## **\*PRE-HEARING STAFF ANALYSIS\***

### **Rezoning Petition No. 2008-078**

**Petitioner:** W.P. East Acquisitions LLC

**Request:** INST, institutional to R-17MF (CD), multi-family residential, conditional

**REZONING
SITE PLAN
REZONING PETITION
2008-078**

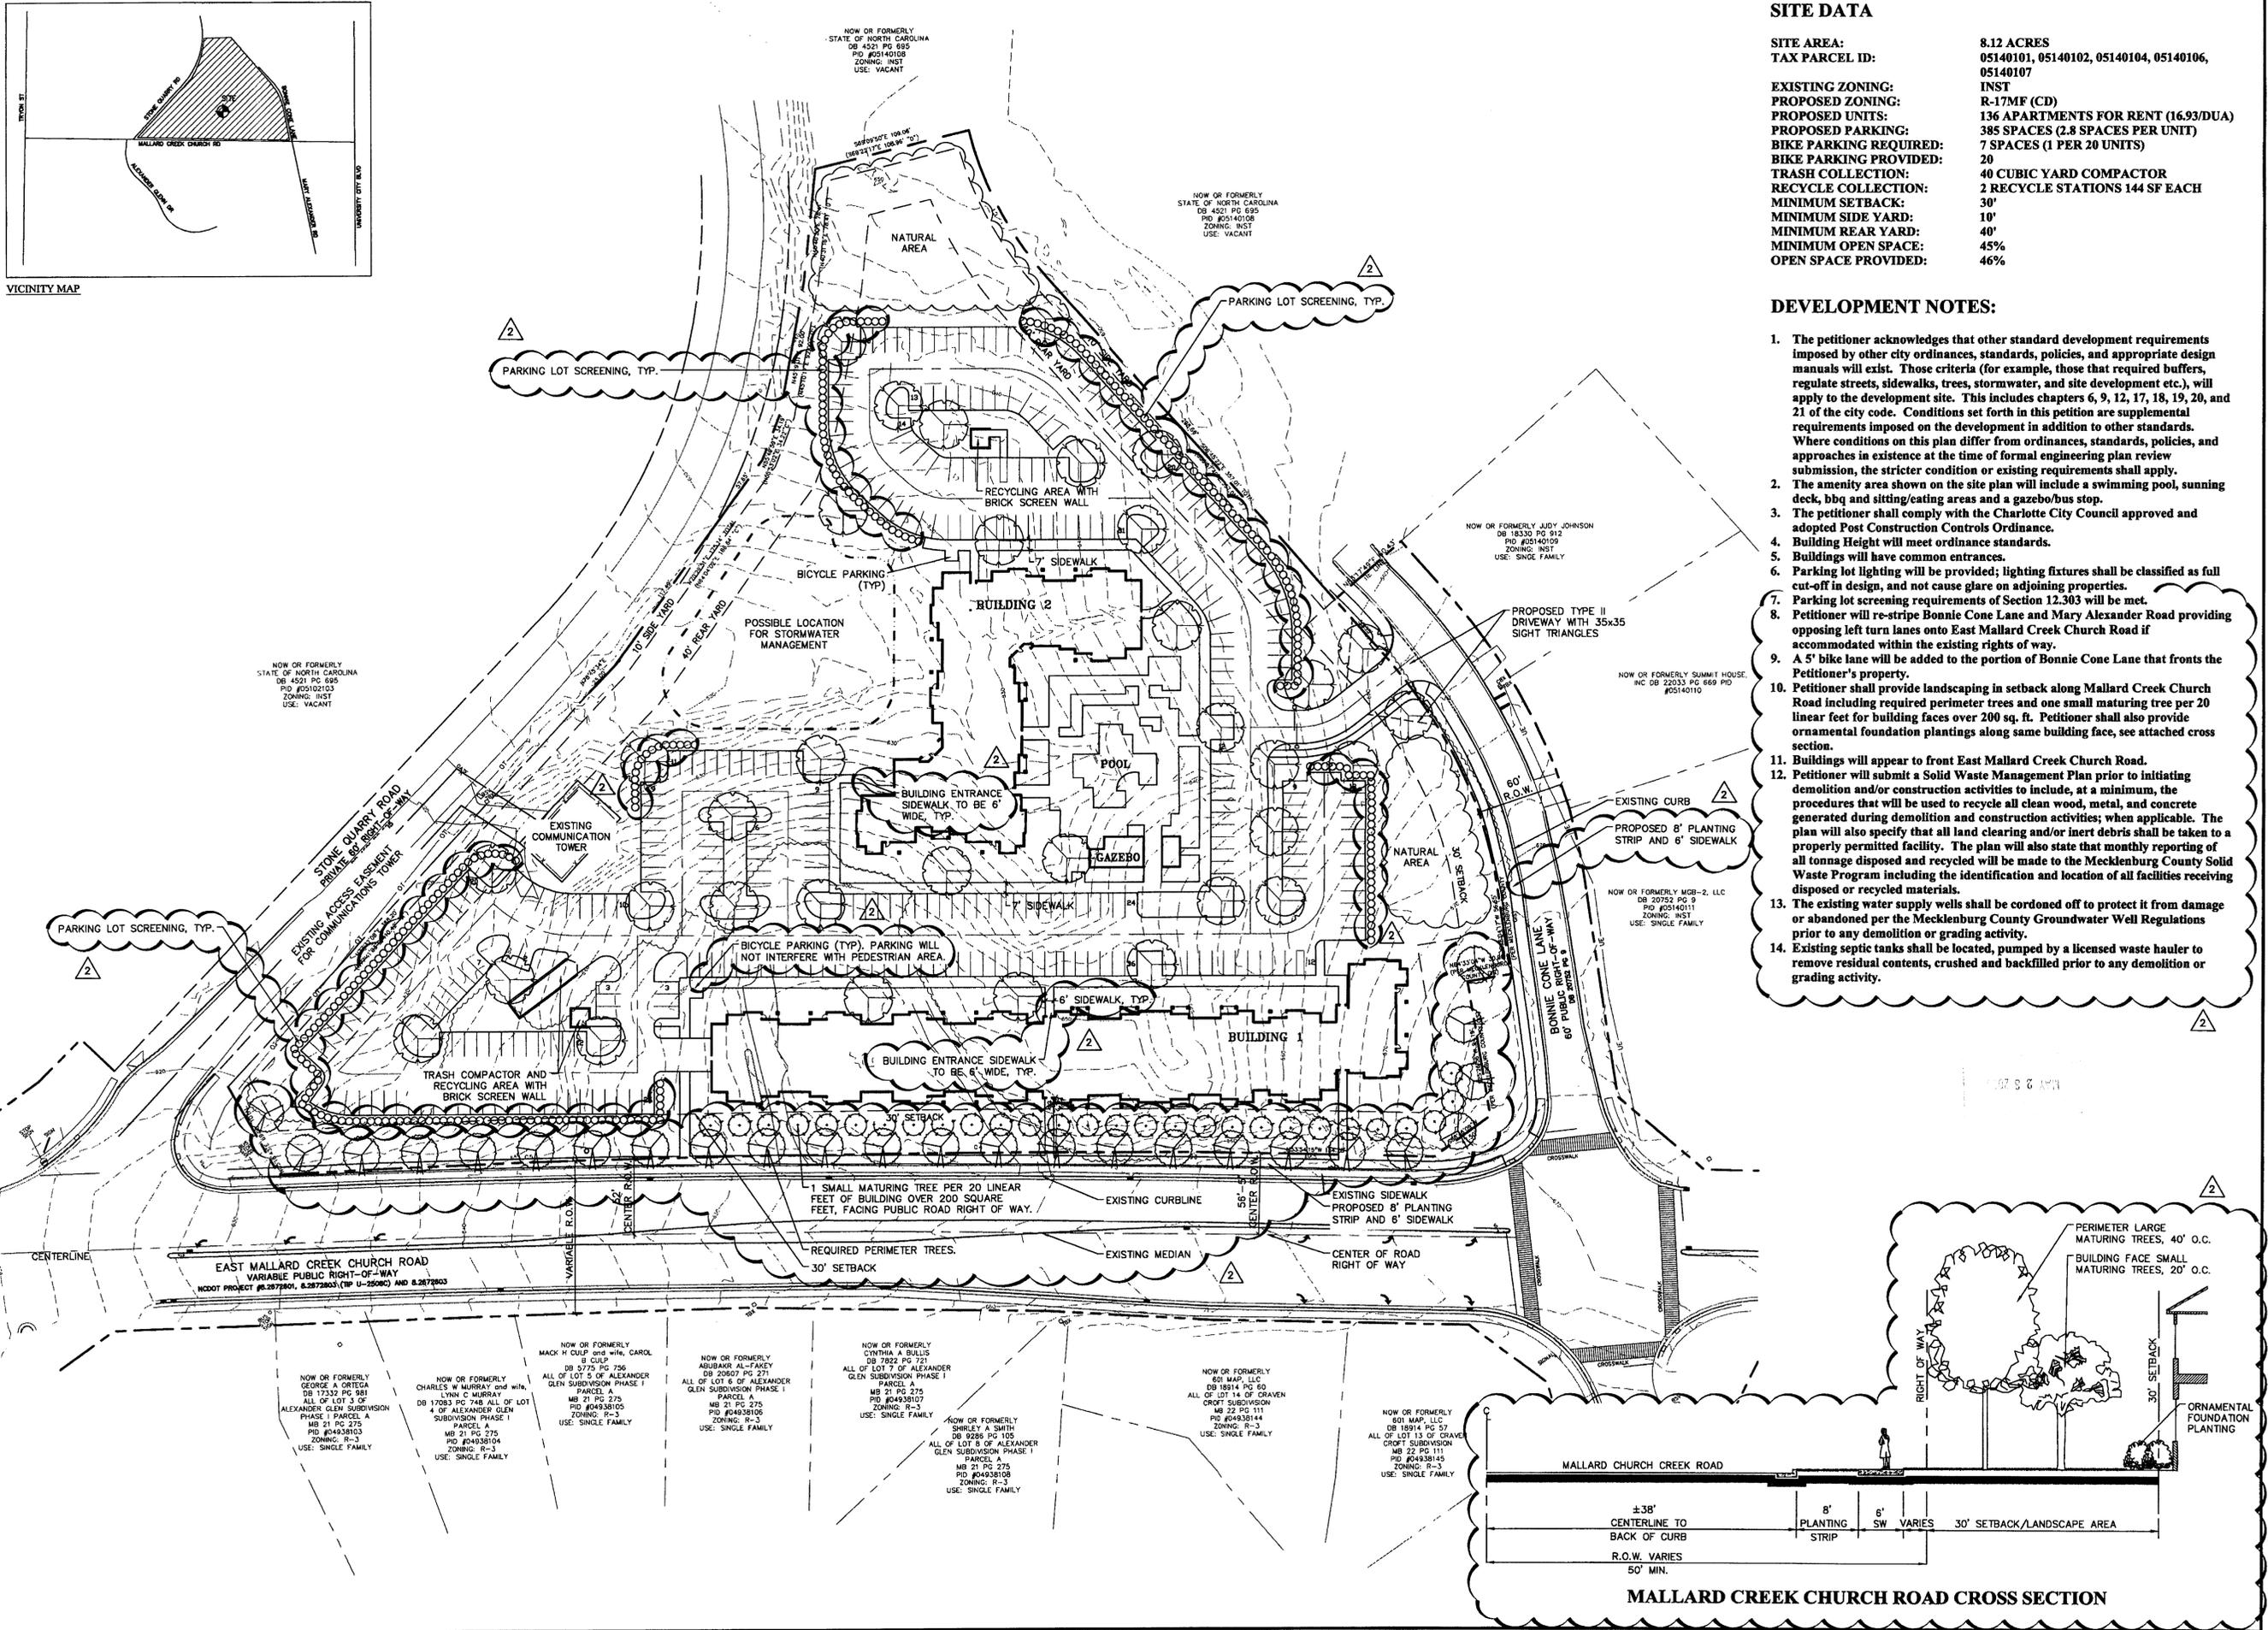
- It appears that there may be conflicts with how trash collection trucks will access the trash compactor area. Please review the alignment for accuracy.

- A minimum 50' front setback is requested along East Mallard Creek Church Road to match existing setbacks along this street.
- The petitioner should provide landscaping with trees and shrubs located in the front setback area, with a development note added detailing what landscaping will be provided. Building wall areas over 200 square feet and facing a public right-of-way shall provide a minimum of 1 large maturing tree per 30' of linear wall area, or one small maturing tree per 20' of linear wall no closer than 15' to the wall. The street trees shown along E. Mallard Creek Church Road cannot be counted toward this landscaping requirement.

- Provide a cross-section of the landscape plantings to be provided in the 50' front setback.
- The site data table should be revised to state that a minimum of 45% open space is required. Please provide the actual percentage of open space provided on the site.

- The site plan should be revised by adding labeling information describing the various dashed and solid lines that are located between Building #1 and E. Mallard Creek Church Road: 1) the current edge of the E. Mallard Creek Church Road right-of-way line, 2) the property line/proposed zoning line, and 3) the 50' setback as measured from the edge of the future rights-of-way. The current lines are difficult to identify.

- Revise the site plan to show the areas where parking lot screening will be provided. Modify note # 7 to state that the parking lot screening requirements of Section 12.303 of the Zoning Ordinance will be met.

- The planting strips along Bonnie Cone Lane are required to be eight feet wide, with a six-foot sidewalk, not a four-foot planting strip with a five-foot sidewalk.

- The bicycle parking area should not interfere with the pedestrian sidewalk system. The site plan should take into account the length of a typical bicycle, and no portion of the bicycle should extend into the seven-foot sidewalk pedestrian area.

- The building entrance sidewalks need to be a minimum of six feet wide.
- Provide building elevations for buildings facing East Mallard Creek Church Road and Bonnie Cone Lane, and elevations of the sides of the buildings facing Stone Quarry Lane. Label the building materials on the building. The provided elevation is not labeled as to what building it is, what street it faces, nor does it identify what building materials are proposed for the various portions of the building.

- Buildings should appear to front East Mallard Creek Church Road.
- All LUESA comments should be addressed including a commitment to a solid waste management plan and the addition of notes regarding the existing well and septic tanks.
